OBJECTION to

22/03033/F, the conversion and infill extension of equestrian stables to create a single residential dwelling at The Stables, College Farm, Main Street, Wendlebury OX25 2PR.

PROPOSED ELEVATIONS

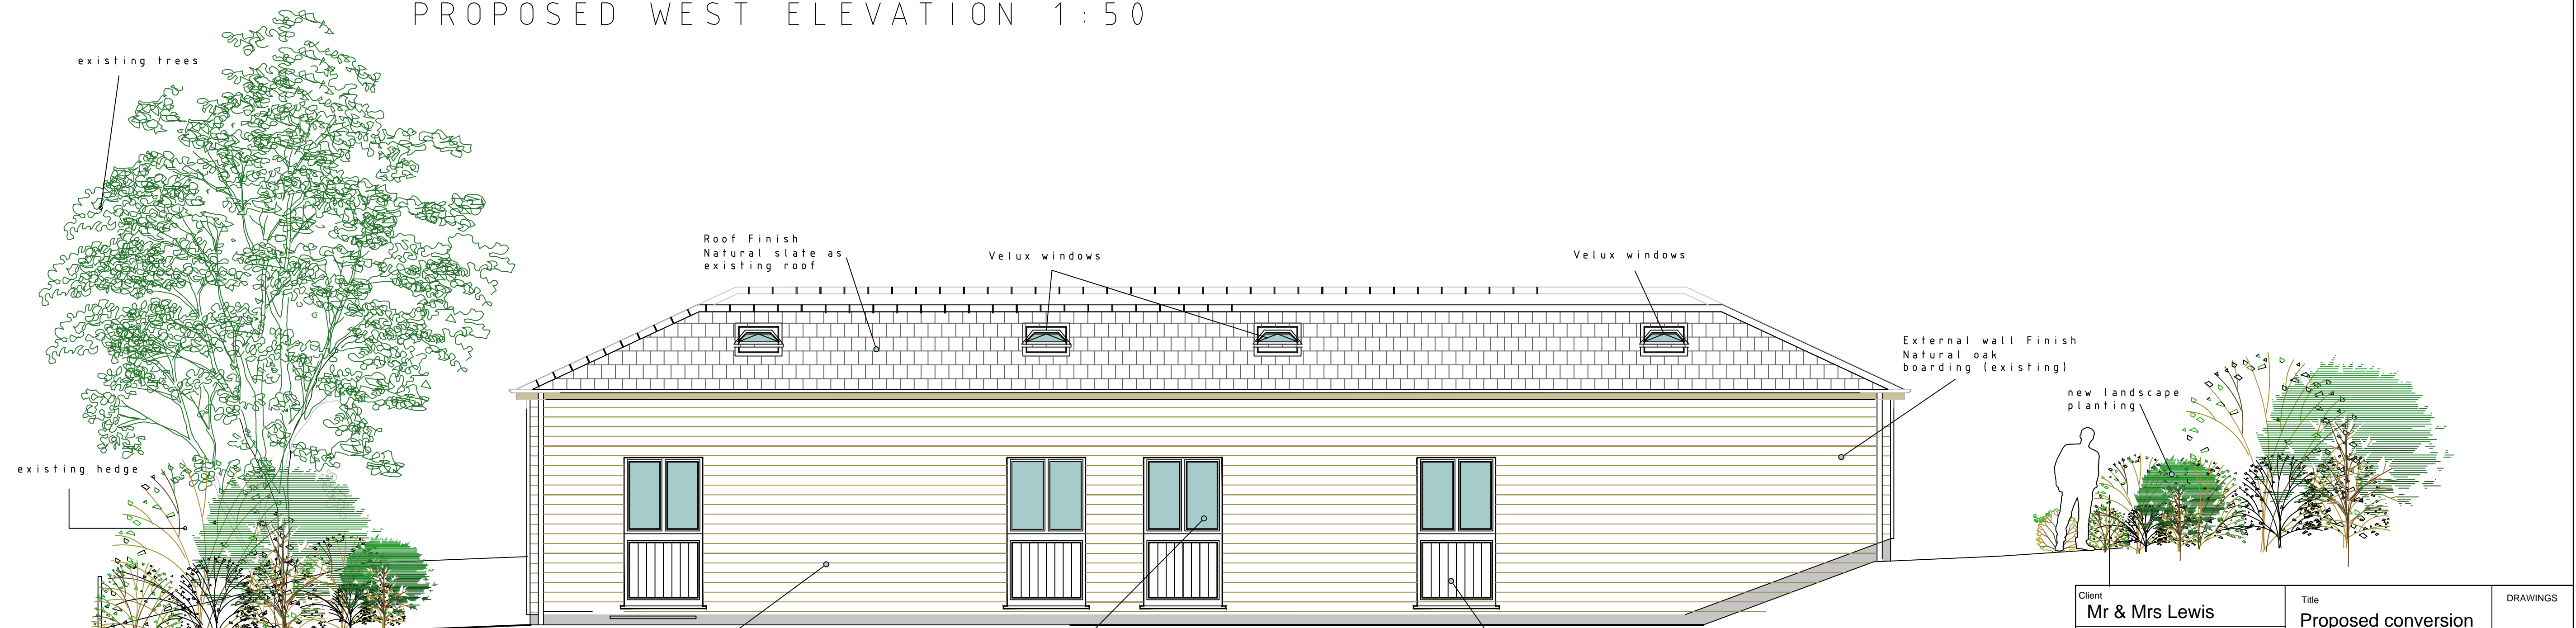
The numerous roof lights, velux windows and large windows, as well as outdoor security lights associated with properties of this size will cause even more disturbance. The main bedroom of the Old Dairy, in particular, will be directly affected by the likely significant noise and light pollution. As can also be seen in the photos, the Stables are slightly angled so that existing openings have views towards the Old Dairy. Therefore, the large windows that will serve the sitting room will afford views into the Old Dairy. The velux windows proposed for the roof on this side will allow further direct views to the Old Dairy, including into the bedroom on the first floor. As already mentioned, even people standing in the proposed front area have views into the Old Dairy, especially during the long winter months when the trees between the properties are not in leaf. Added to this people generally have an outside sitting area directly outside their sitting room and again this affords direct views into the garden, living room and bedroom of the Old Dairy.

PROPOSED ROOF PLAN

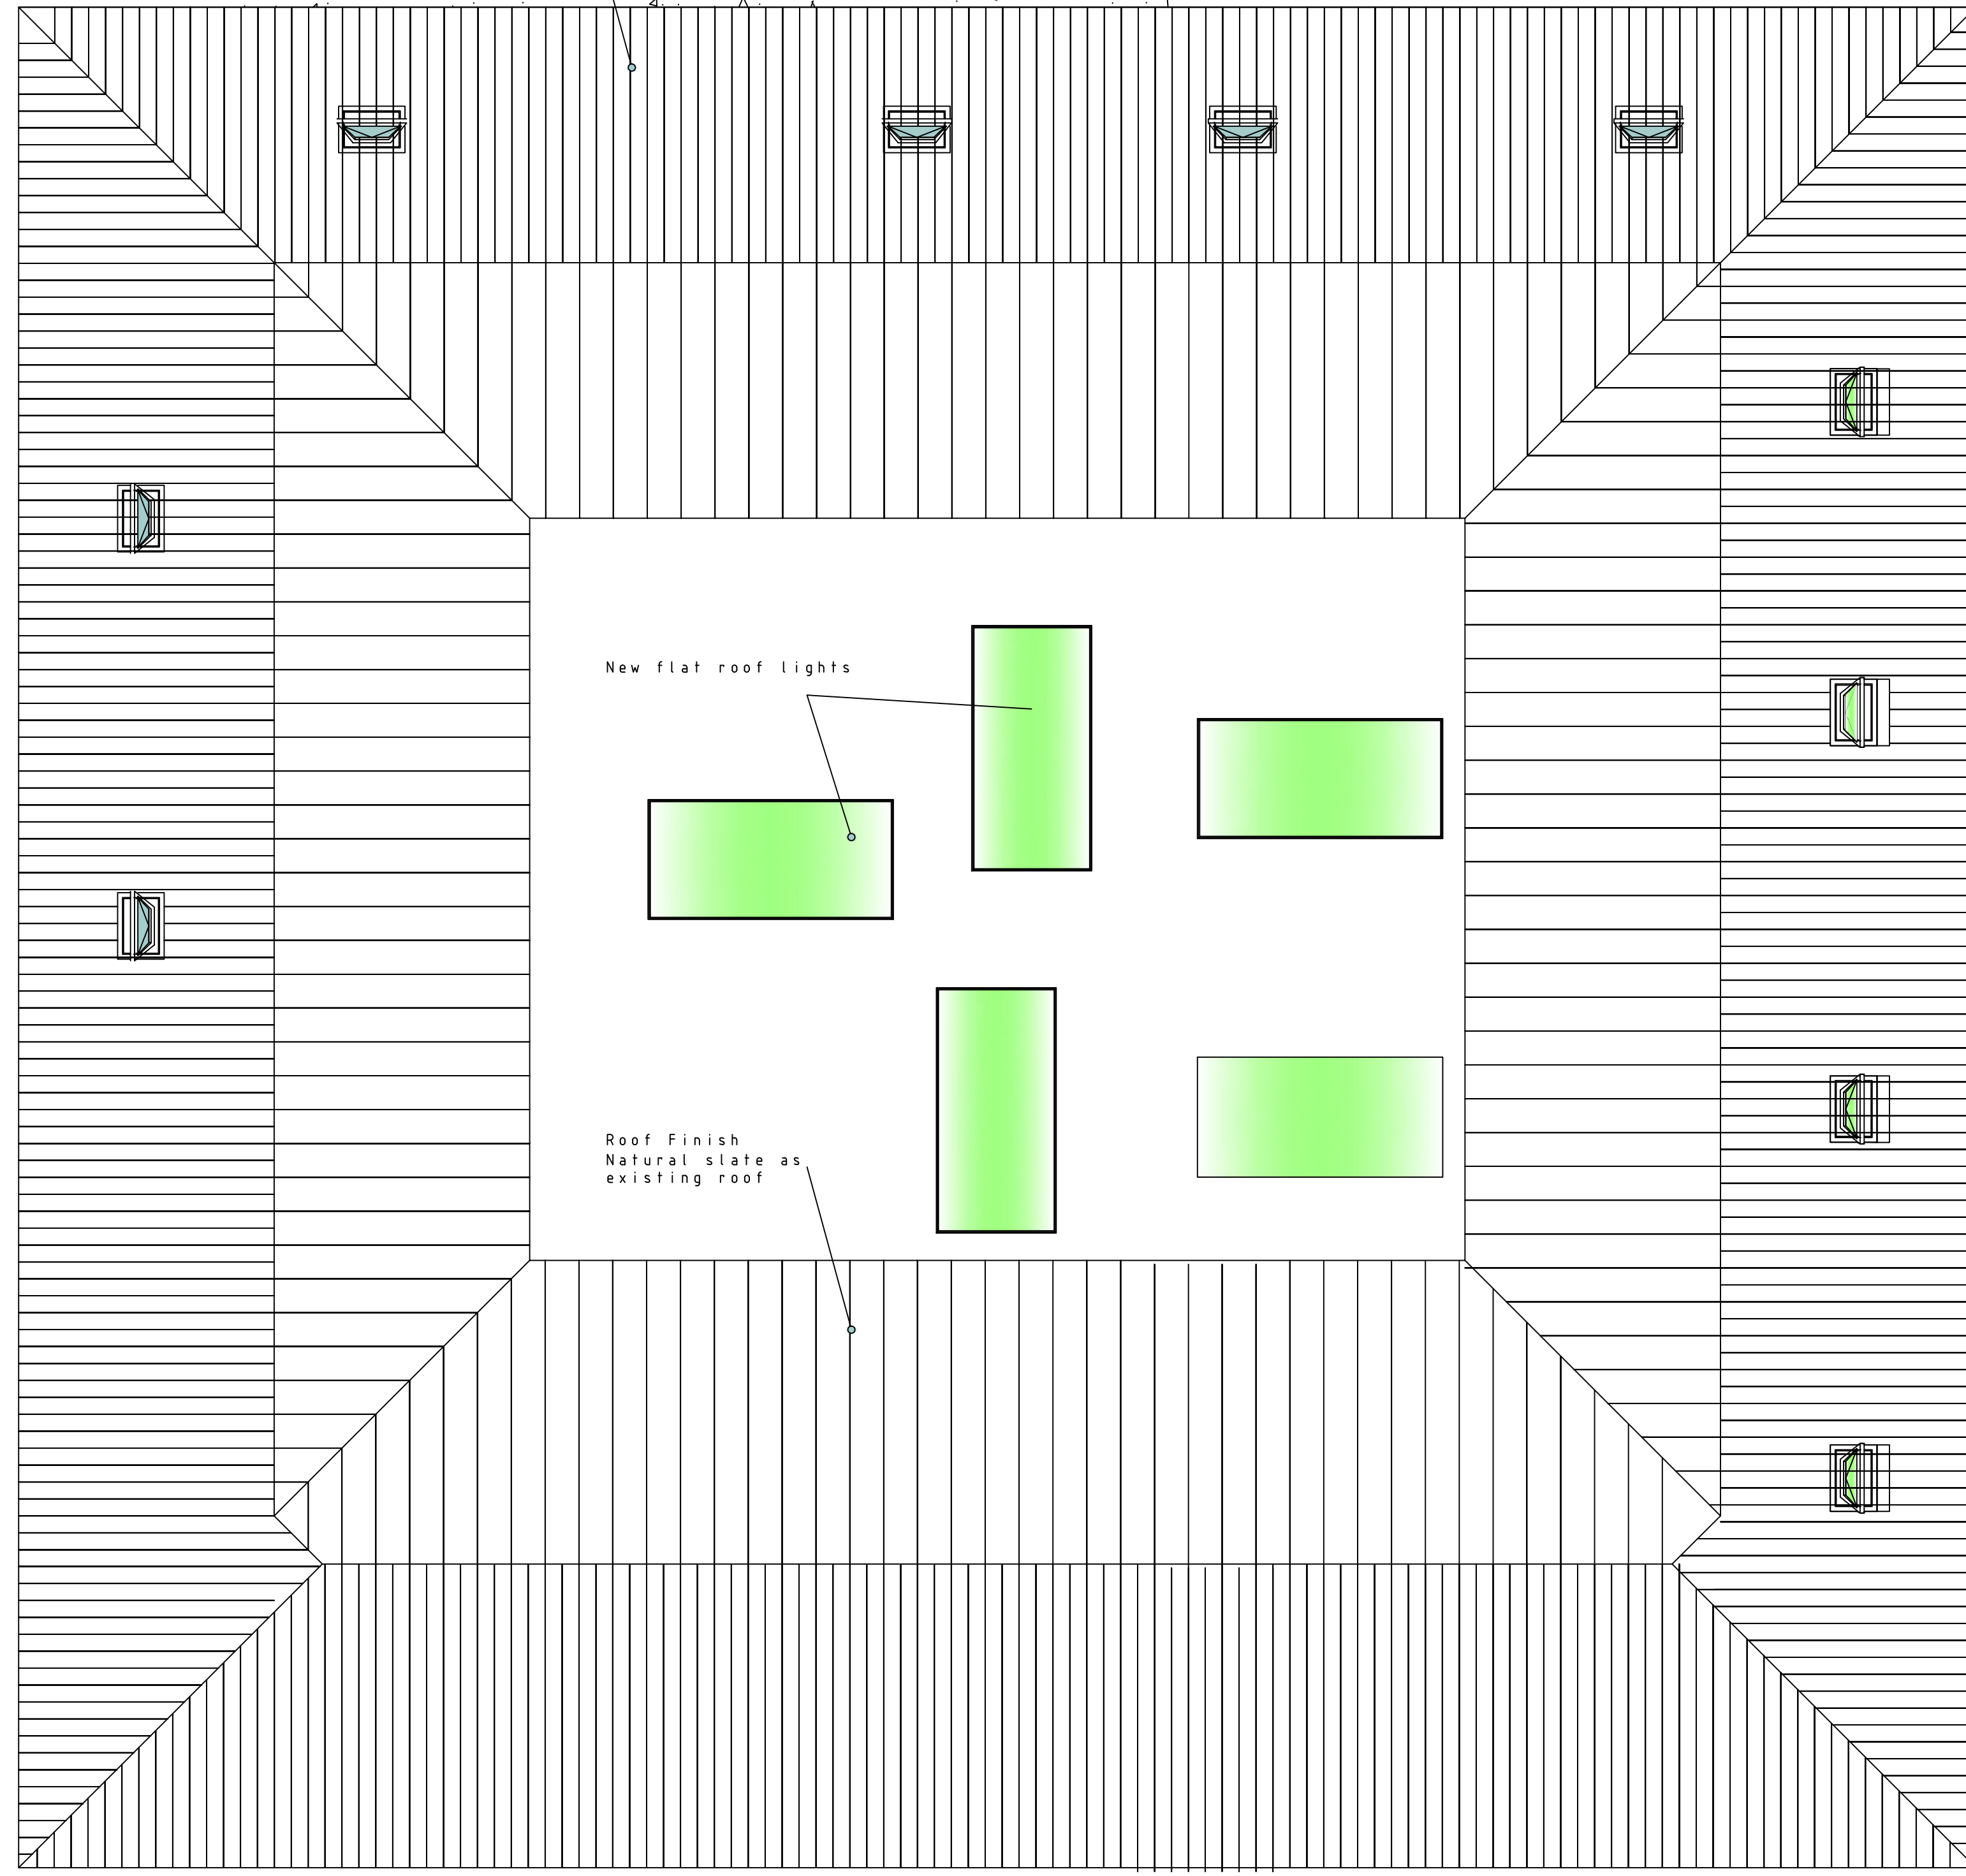
It is known that light emissions from roof lights and windows have a detrimental impact on the flight patterns of nocturnal creatures. This proposal has numerous roof lights, velux windows and other large openings, which will harm the quality of the night sky and negatively impact on nocturnal protected species, such as bats.

SITE PLAN 1:500

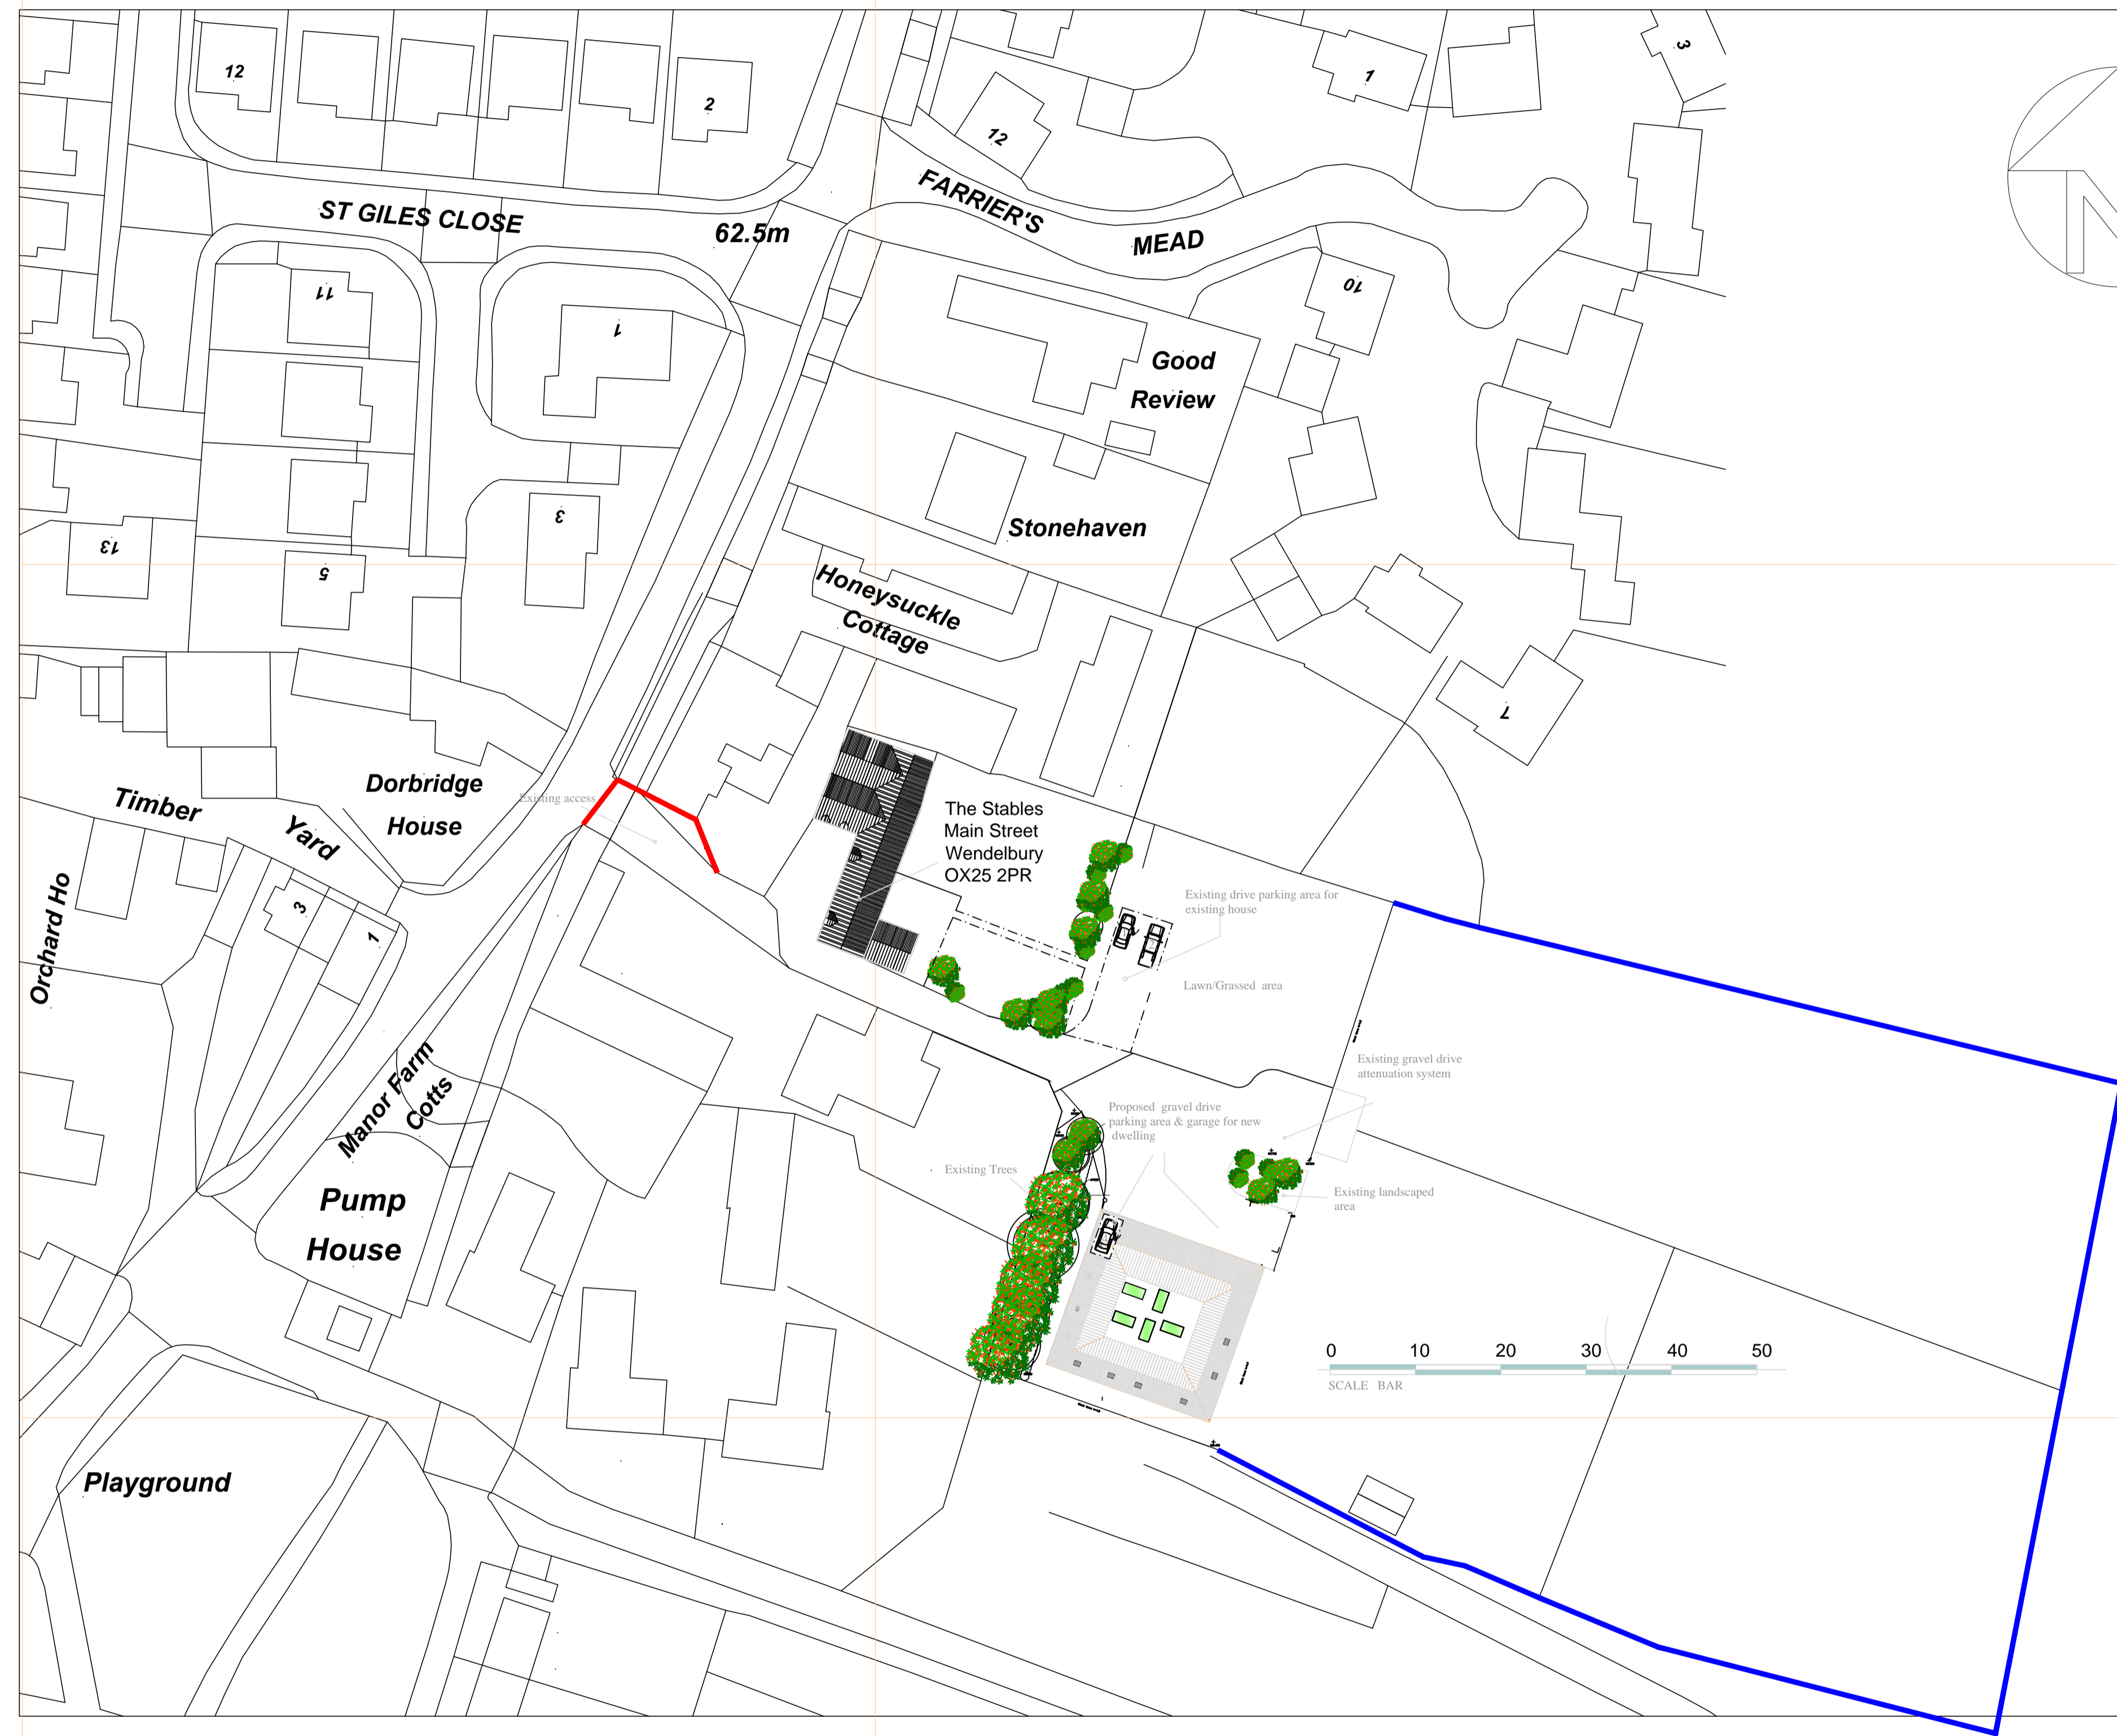
The garage is proposed to be immediately adjacent the rear garden area of the Old Dairy. Cars are already visible above the garden fence of the Old Dairy, when parked in this area. The use of this area for parking will cause noise and light nuisance for the Old Dairy. Car lights will shine directly into the main bedroom and the living room of the Old Dairy; people in the vehicles will have direct views into these rooms and even standing outside their vehicles they will have a direct sight line into habitable rooms of the Old Dairy.

Bearing in mind the application seeks to provide parking for ten cars, the comings and goings will be equivalent to five normal properties not one; and the disturbance is significantly heightened because of the ground level changes. Car lights, noise from engines and car doors, as well as fumes will make the enjoyment of the Old Dairy garden area near impossible.

It is noted that the application states that the waste and recycling bins will be located to the side of the building next to the garage. So, it will practically adjacent to the Old Dairy, where it would only add to the disturbance and nuisance referred to above. There have already been problems with pests, namely rats, which the pest control officer deduced as being associated with the stables and the applicant's chicken run. Storing waste adjacent to the rear garden of the Old Dairy will potentially increase the problem of rodents and other pests.
